# Planning Services Sign Permit Review Form

Date of Submittal	Application Number	Applicant	Landowner
12/28/2023	SIGN2312-0261	Sansom Memorial Community Church Inc.	Alpha Signs and Lightning, inc.

Contact Person	Contact Number	Sign Location	PIN Number
Joseph Bain	910-635-6226	2896 Arrowhead Road. Dunn, NC 28334	1505-96-9870.000

Cabinet Sign: Exterior, Double-Face, Aluminum Construction, Plastic Face (Flat) w/ Translucent DPV Graphics, Internally Illuminated, EMC

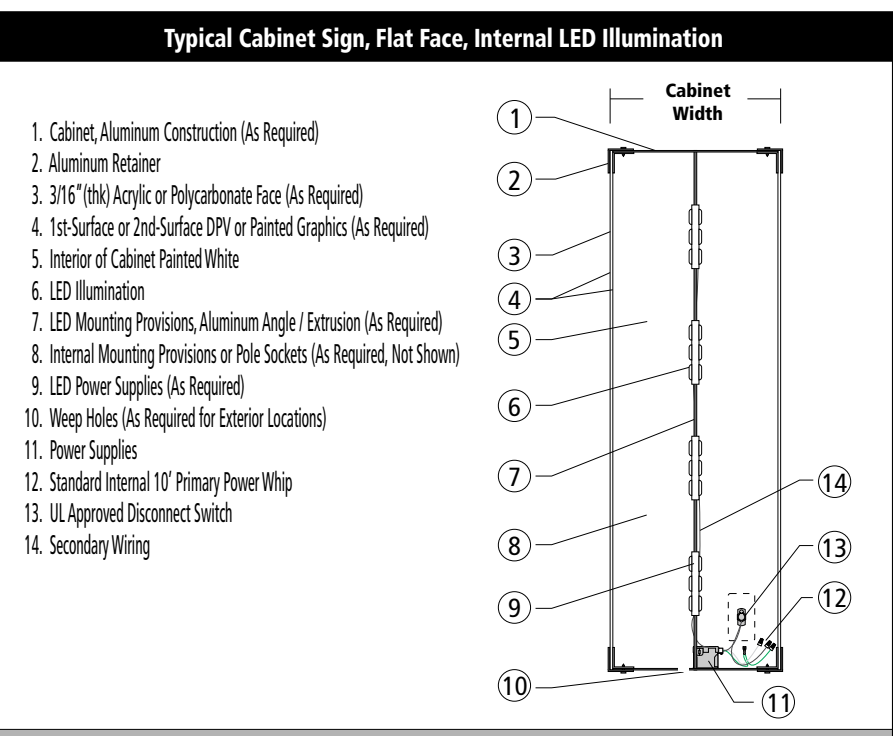
<b>Comments</b>	<p>-Please provide the distance from the sign on the property to the ROW.</p> <p>-Up to 35% of the sign copy area may be LED message board. Please reduce the proposed LED message portion of the sign to 20.4 square feet or less to meet the requirement. Currently, 22.59 feet are proposed.</p>
-----------------	---
